From: Sue Howell
Sent: 31 October 2017 14:54
To: Michael Eastham
Subject: FW: Amended site layout - the Lillies Caravan park site, Yapton Road, Barnham

Subject: Amended site layout - the Lillies Caravan park site, Yapton Road, Barnham

Flat Block A
Floor Plans & Elevations
Plots 19-24

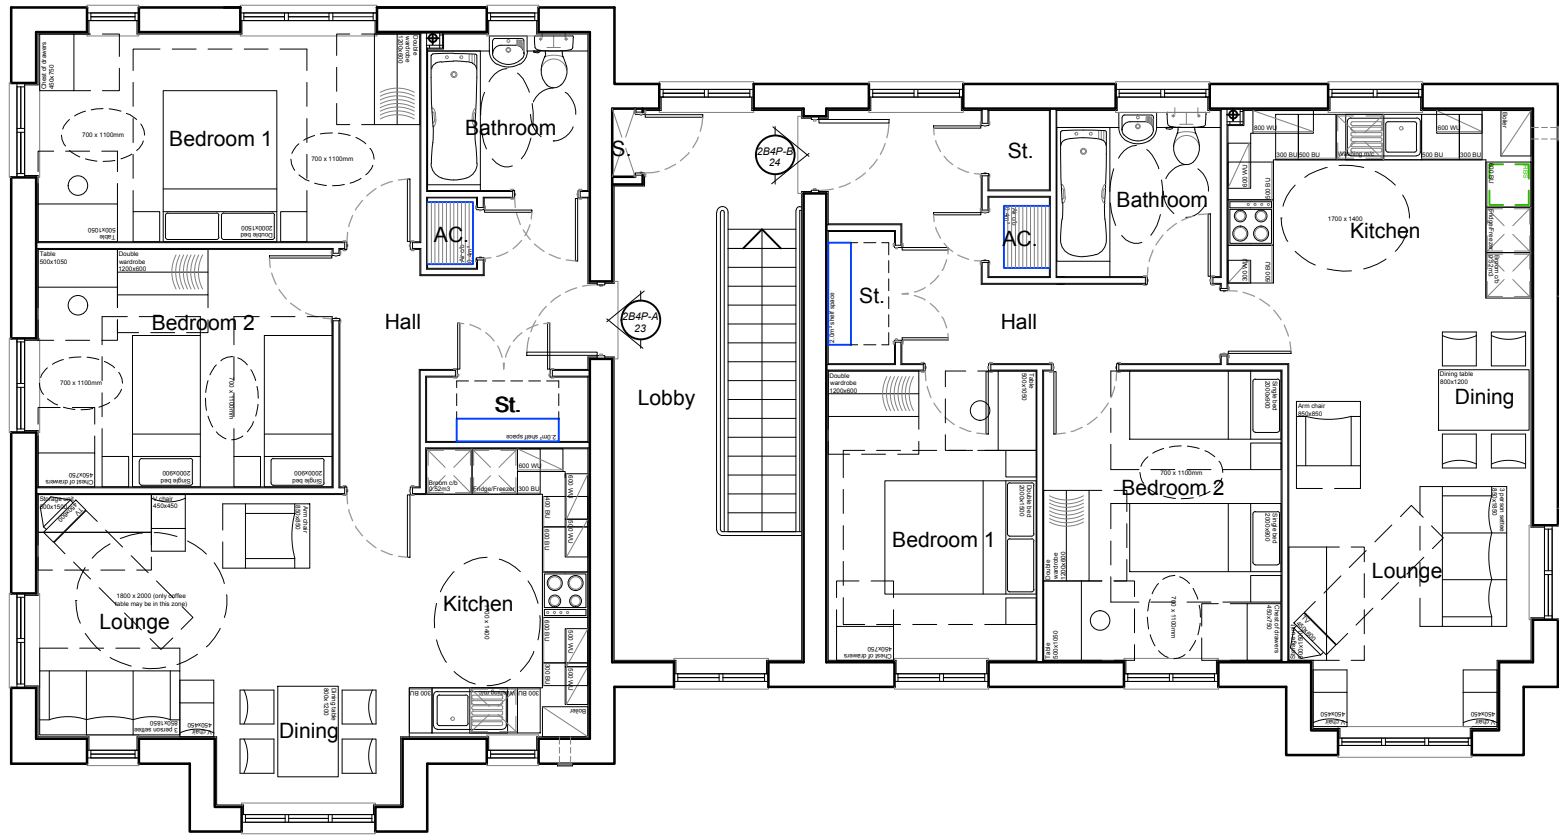
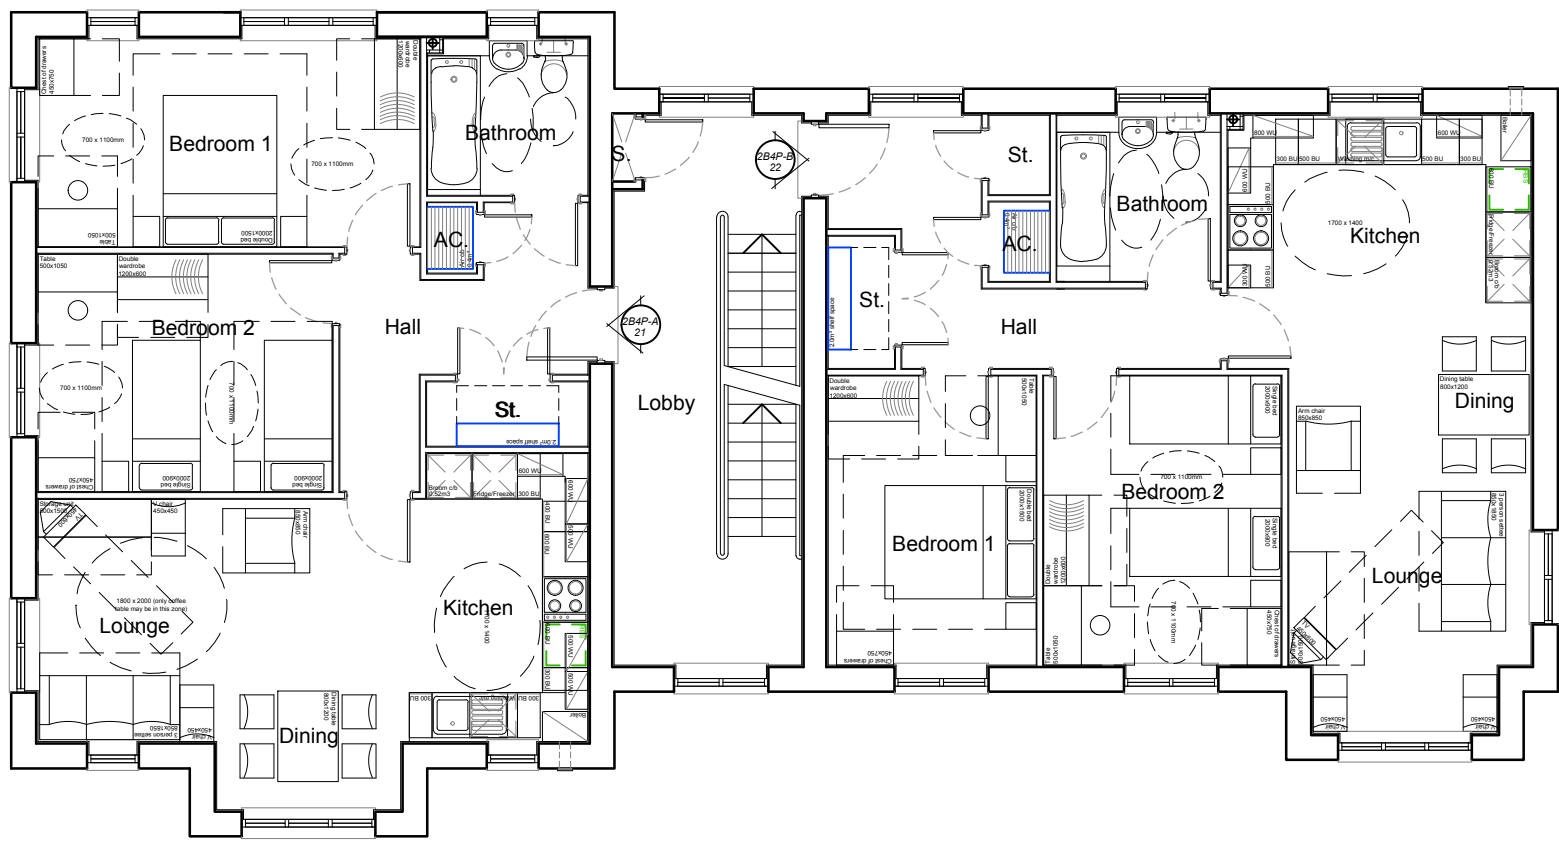
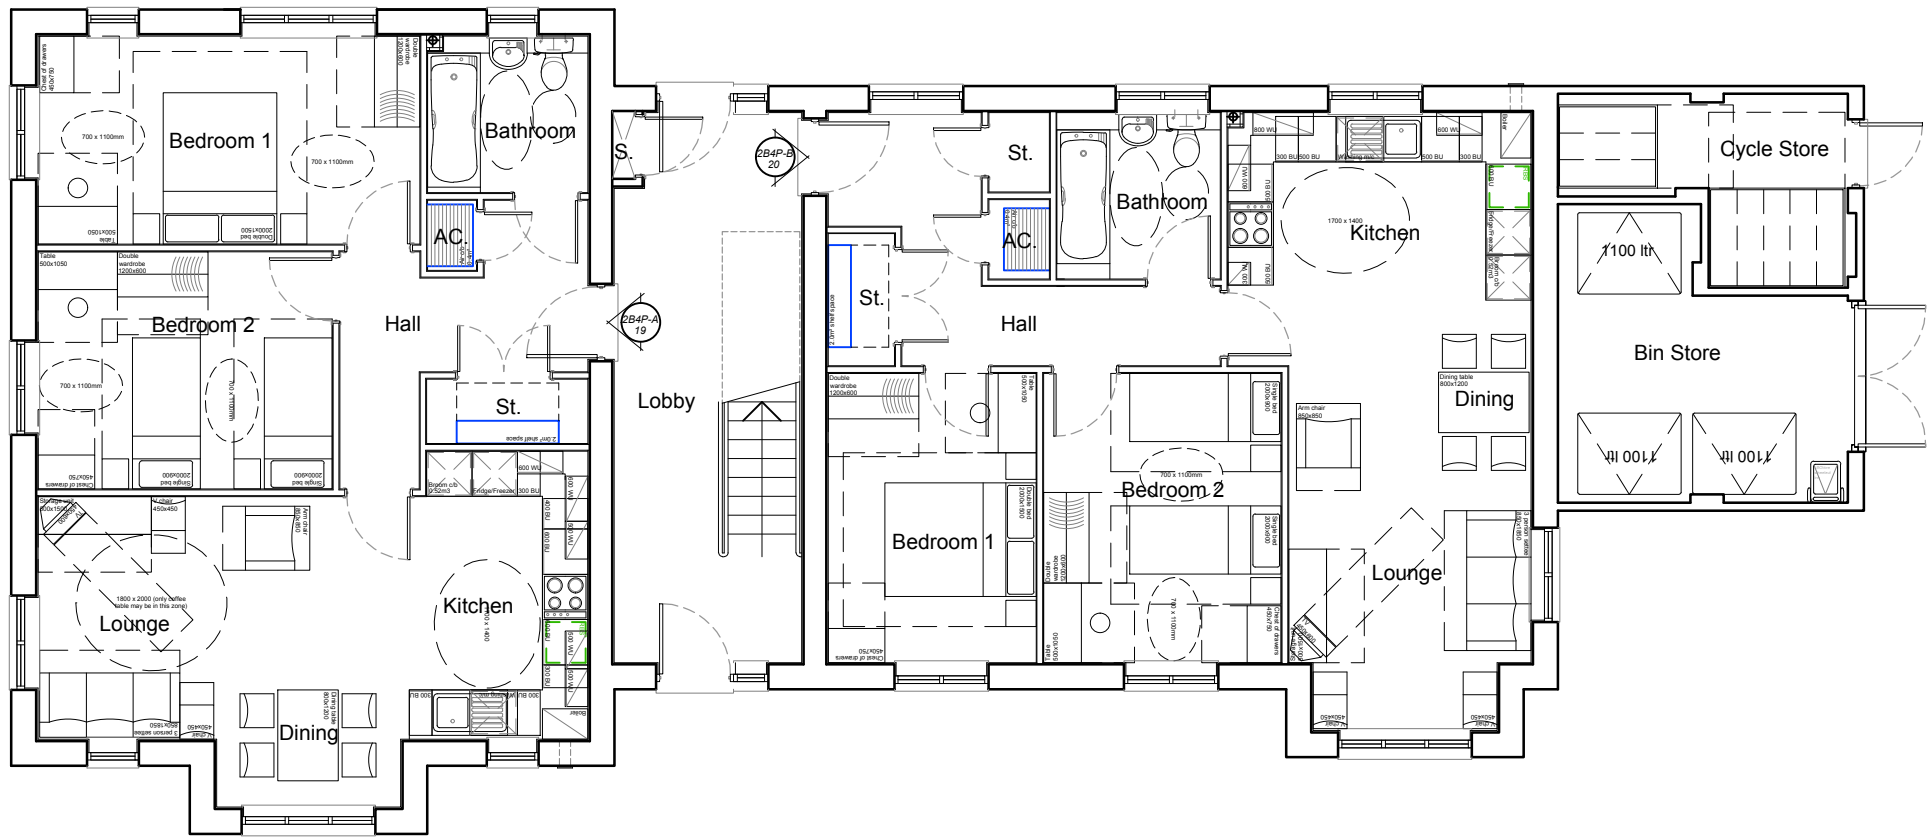
For clarity a cross section through this area particularly from the corner of the flats 19-24 would show this in context. Also further detail of the SuDS depression regarding flow and water holding capacity could be passed back to the drainage engineers for further comment as to whether they would have any concern if proposed as primary POS for this development?

The now indicated attenuation basin to the centre of the POS is also of concern and would require clarification of whether this will be a standing water body? And what element of the year this will be the case? This area only depletes the POS as it would then not be classed as usable POS? and my concern also is regarding proximity of this in relation to Flat Block A 19-24 which should be raised and addressed.

The flat block is deemed ok location wise to the basin, no issues from the ADC Drainage consultant.
